CITY OF ALBUQUERQUE

Re: JOURNAL CENTER – TRACT 5 – OFFICE BUILDING A
7601 Jefferson Street NE
Approval of Permanent Certificate of Occupancy (C.O.)
Engineer's Stamp dated 09/02/2005 (D-17/D3)
Certification dated 08/01/2006

**Re: Journal Center Tract 5 – Office Building A, Corner of Masthead St and
Tiburon St NE, Grading and Drainage Plan
Engineer's Stamp dated 6-30-05 (D17-D3)**

Re: Drainage Plan for Journal Center, Tract 5, Building A, ZAP D-17
 Engineer's Stamp Dated July 29, 2005

C101

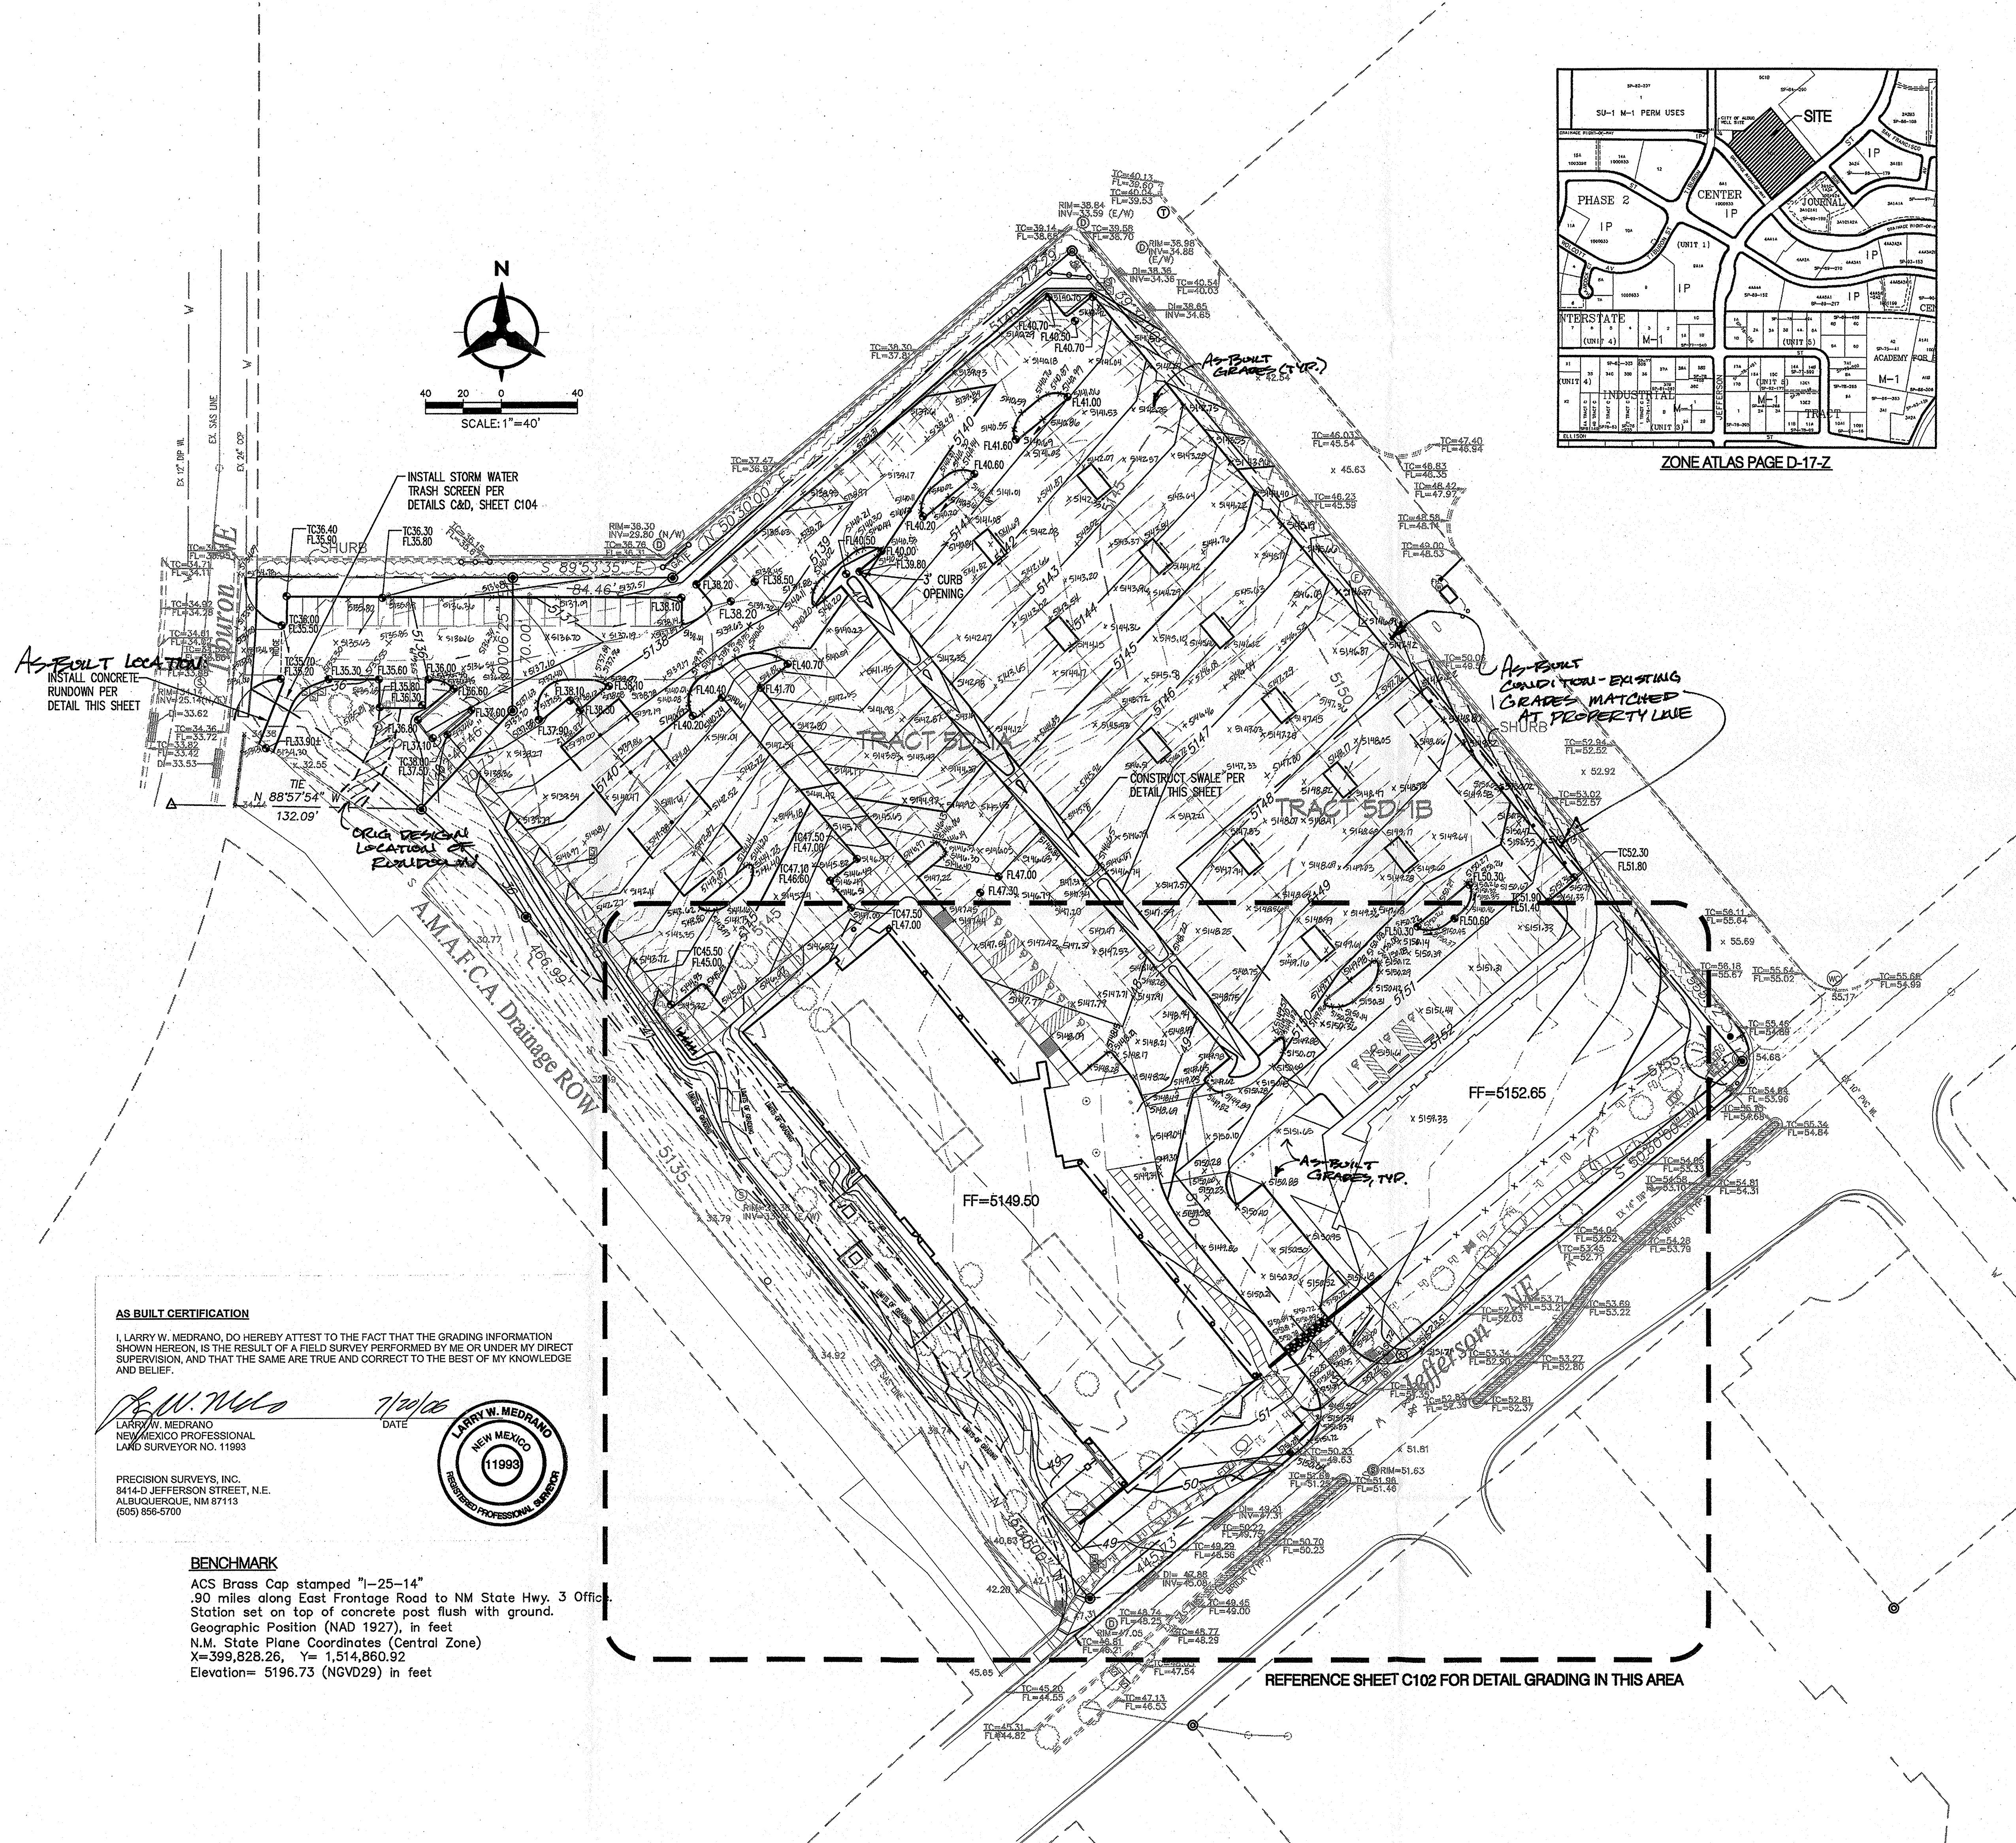
1. AMAFCA has an agreement with Journal Center Corporation for maintenance of the concrete portion of the channel only. Discharge of the roof drains down the grassy slope that is maintained by the management company must be approved by them. AMAFCA recommends connecting the roof drains so that there is only one discharge pipe that would outfall to the lip of the channel or down a concrete swale. The swale would have to be traversable by a mower.
2. Provide detail of the trash screen referenced on Sheet C101.
